Appeal Decision

Appeal Ref: APP/R5510/D/24/3337188

139 North Hyde Road, Hayes, Hillingdon UB3 4NR

- The appeal is made under section 78 of the Town and Country Planning Act 1990 (as amended) against a refusal to grant approval required under Article 3(1) and Schedule 2, Part 1, Class AA of the Town and Country Planning (General Permitted Development) (England) Order 2015 (as amended).
- The appeal is made by Mr Jigar Chheda against the decision of the Council of the London Borough of Hillingdon.
- The application Ref is 13207/APP/2023/3059.
- The development proposed is described as construction of one additional storey to original footprint.

Project		Drawing		
ENLARGEMENT OF BUNGALOW BY CONSTRUCTION OF ADDITIONAL STOREY		PLANS, ELEVATIONS		
AT 139 NORTH HYDE ROAD HAYES UB3 4NR		Scale	Date	Drawing No.
		1/100@A3	OCT.2023	J/602/01
		Drawn		A

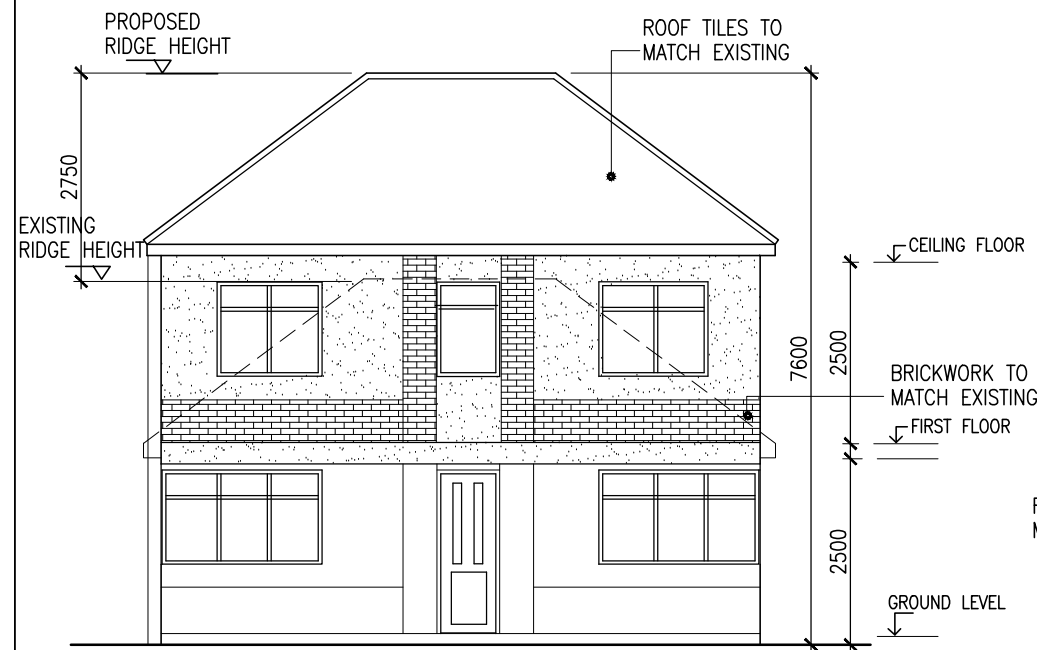
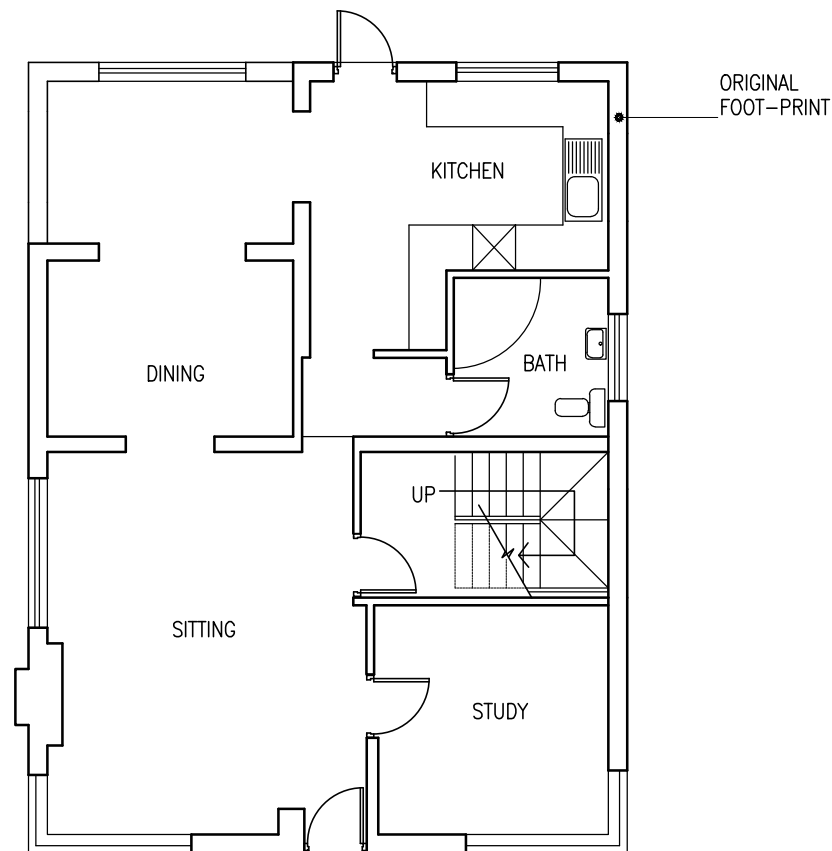
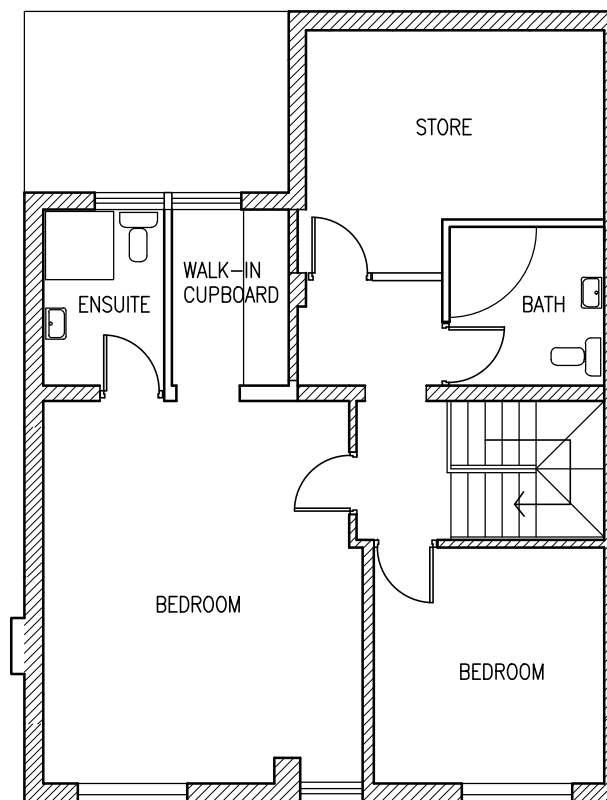
11. The extension would have first floor rear windows facing No 4. However, the plans submitted indicate that these would be obscure glazed. In addition, the proposal's rear elevation would be stepped in, and a reasonable gap would be provided between its windows and No 4. As such, the proposal would ensure that the privacy within No 4 and its garden would be maintained to an acceptable standard.

- 1) The development hereby permitted shall not be occupied until the first-floor windows facing No 4 Wyre Grove have been fitted with obscured glazing to at least scale 4 on the Pilkington scale, and no part of those windows that is less than 1.8 metres above the floor of the room in which it is installed shall be capable of being opened. Once installed the obscured glazing shall be retained thereafter.
